6 November 2013

Name: S. Ravi
Address: 388 Abercrombie
Street - Sydney
Darlington.

**Modification Request for the University of Sydney Abercrombie Precinct
Redevelopment: Application Number: MP07_0158 MOD 3**

1 GROUND FLOOR PLAN
SCALE 1:200 @ A1

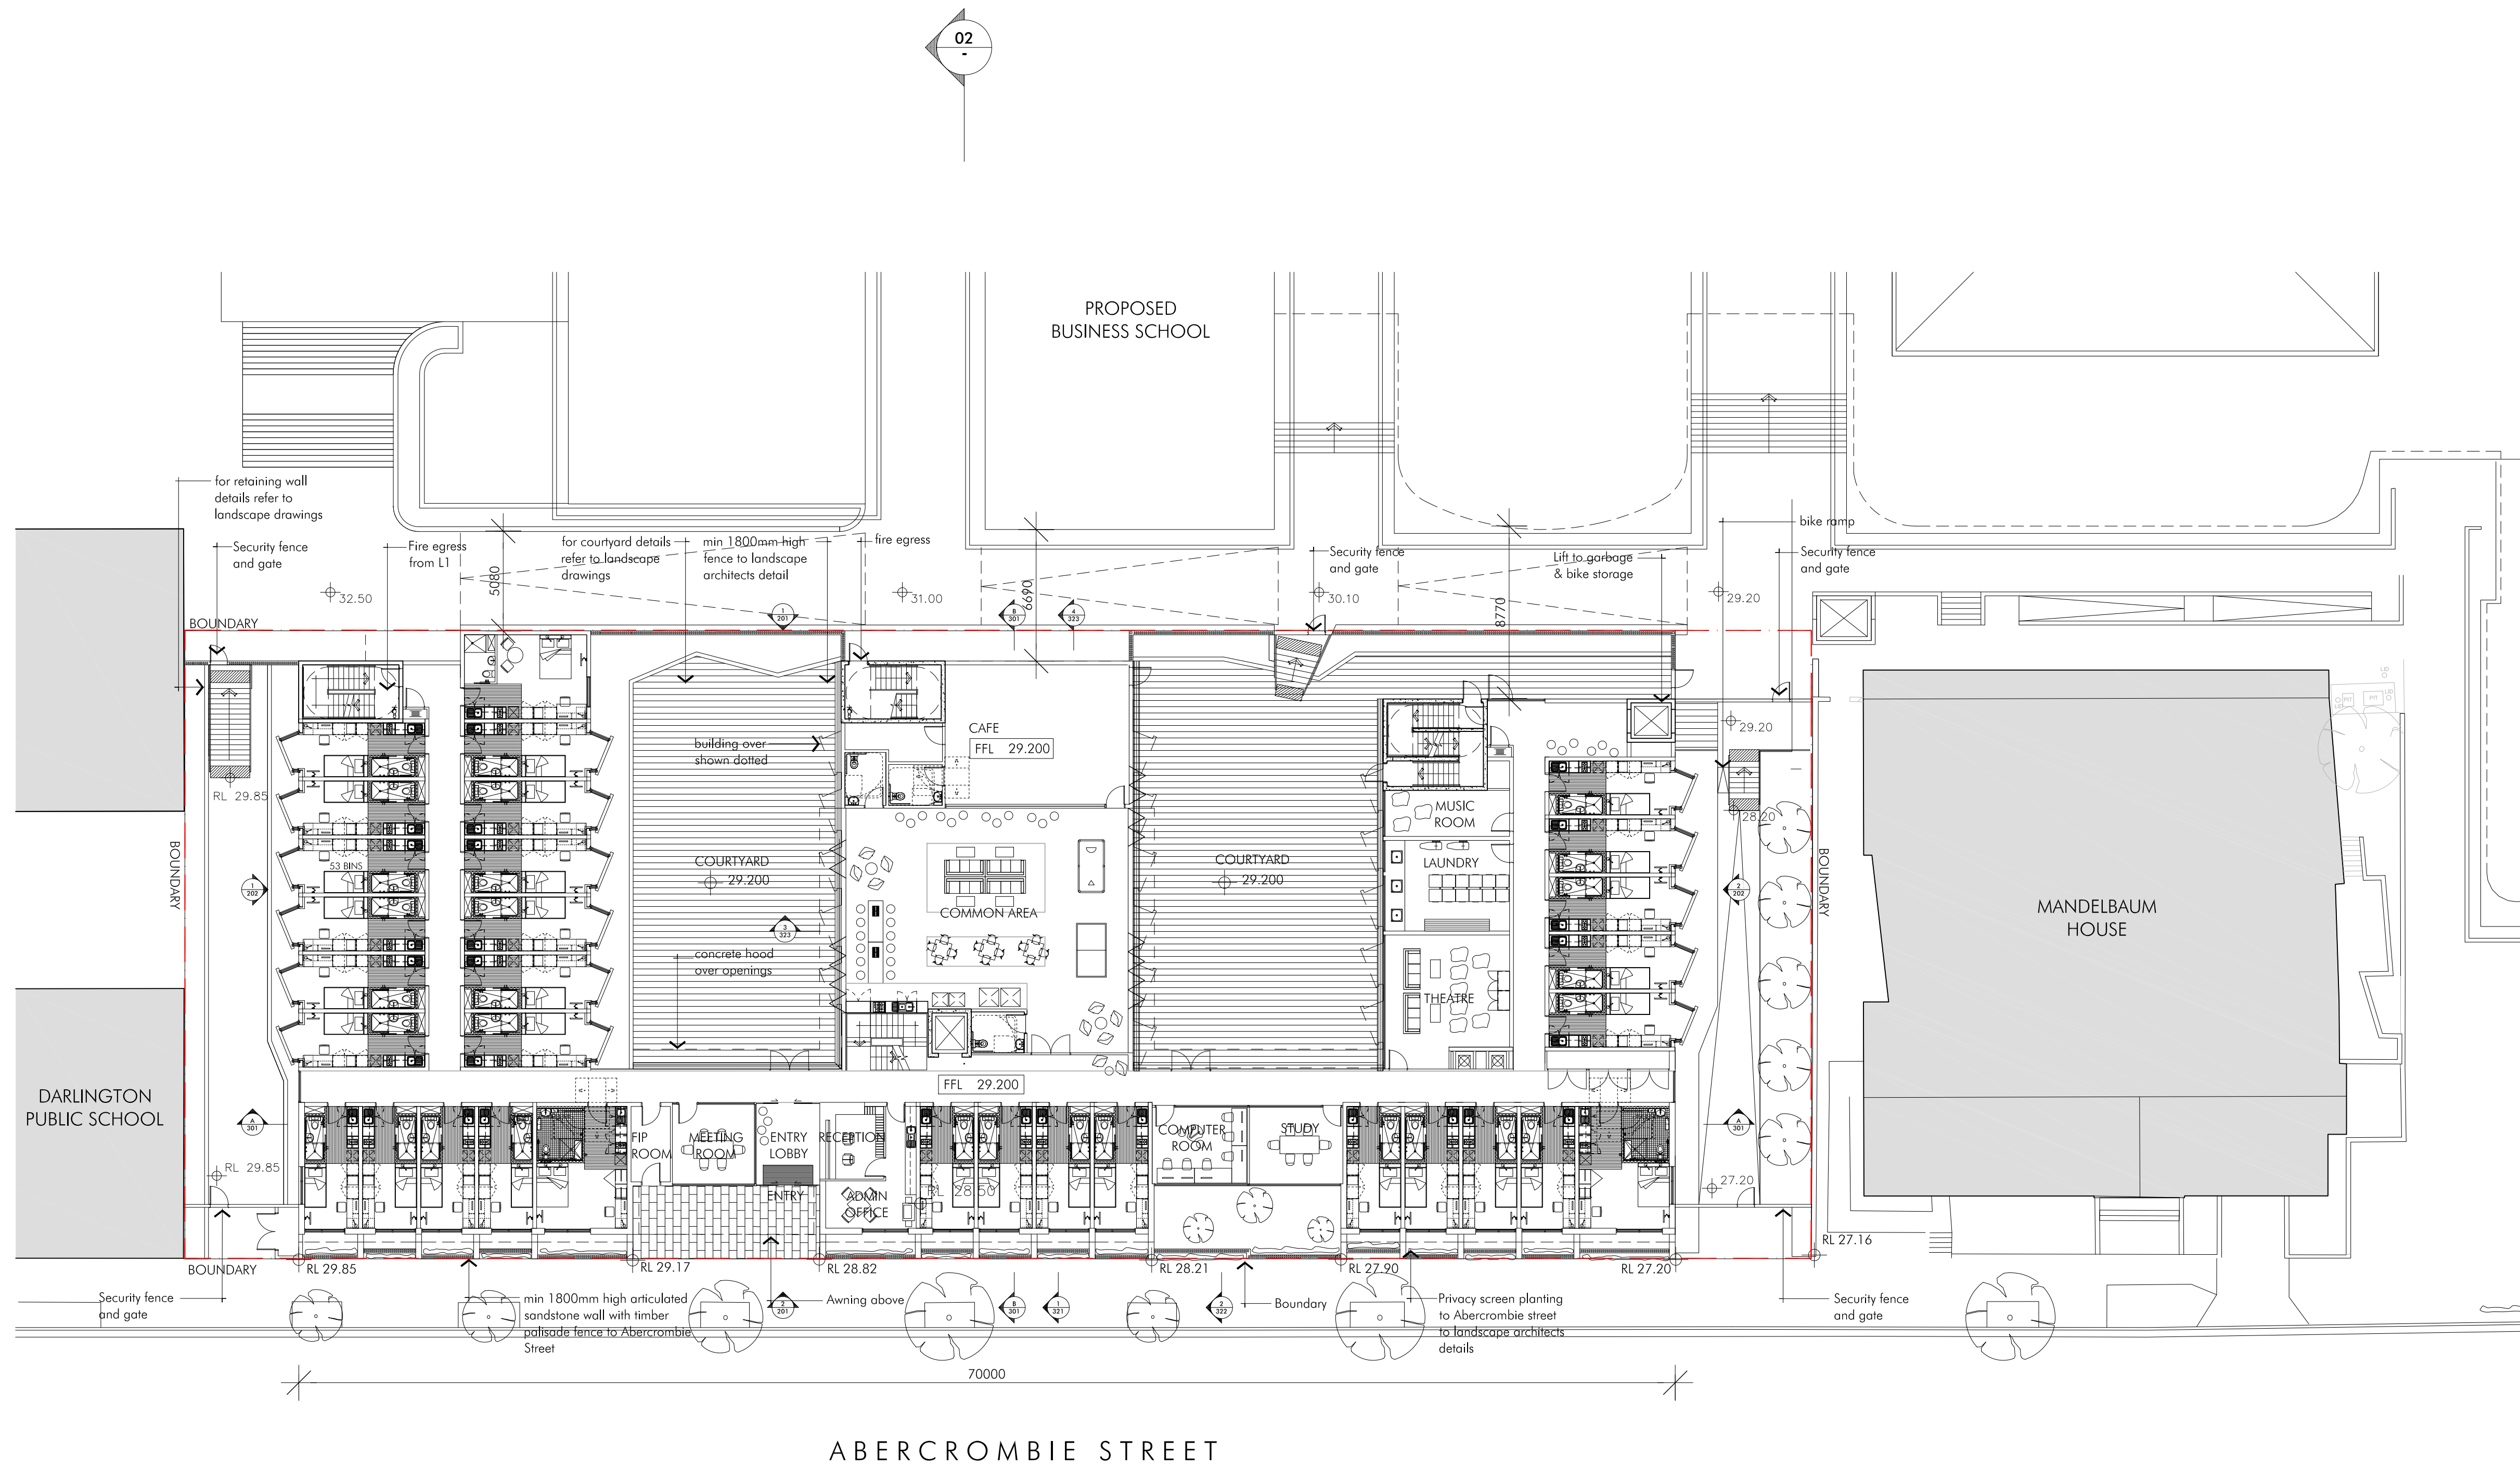
- The front of the Student Accommodation building should be built 2 metres back from the Abercrombie Street boundary. It should be set back from this boundary so that it is in line with Mandelbaum House as it was originally planned and presented to the community. The footprint of the buildings currently on the site, The Shepherd Centre and Boundary Lane Children's Centre, were built approximately 2 metres back from the Abercrombie Street boundary and align with Mandelbaum house. Therefore, the front footprint of the proposed Student Accommodation building should be the same as those buildings occupying the site at present and not be built up to the Abercrombie street boundary.

- The facade of the proposed Student Accommodation building does not reflect the heritage appearance of the Victorian terraces on Abercrombie Street as Mandelbaum House does. Therefore, it should be set back to allow for extensive vegetation and trees to be planted in front of the building on Abercrombie Street to help preserve the heritage streetscape and improve both the aesthetics and the environment of the street.
